PRE-APPLICATION ADVICE

Land adjacent to 110 Ribchester Road, Clayton Le Dale, BB1 9EE

This draft outline planning application has been prepared by Judith Douglas Town Planning Ltd on behalf of the applicants and seeks outline planning permission with all matters reserved except access for one self-build dwelling.

## Site Plan – 110 Ribchester Rd

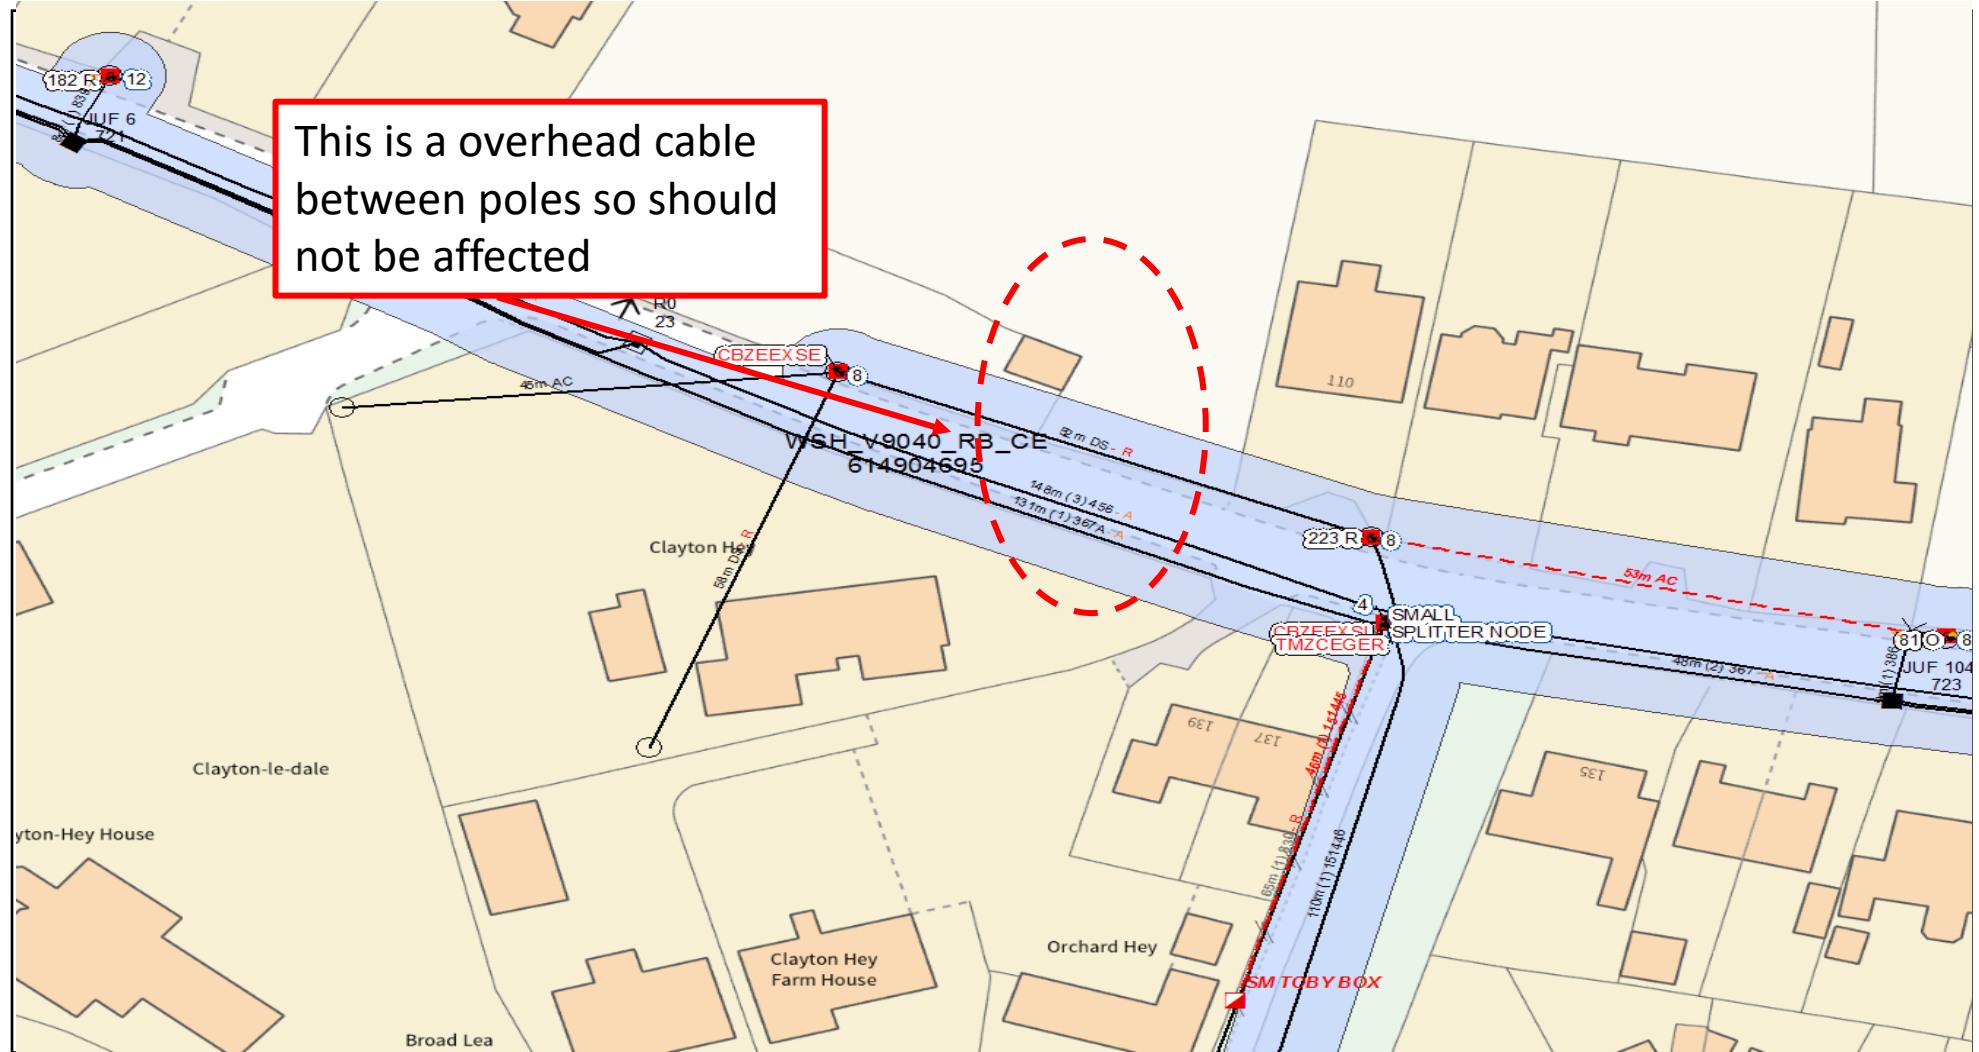
However, the LHA makes the Agent aware that should an application be submitted, a site access plan should show the location of the telegraph pole. This is to ensure that the access will not conflict with the telegraph pole following the extension to the access. Should this be the case, the Applicant will be liable to the full cost of relocating the telegraph pole elsewhere.
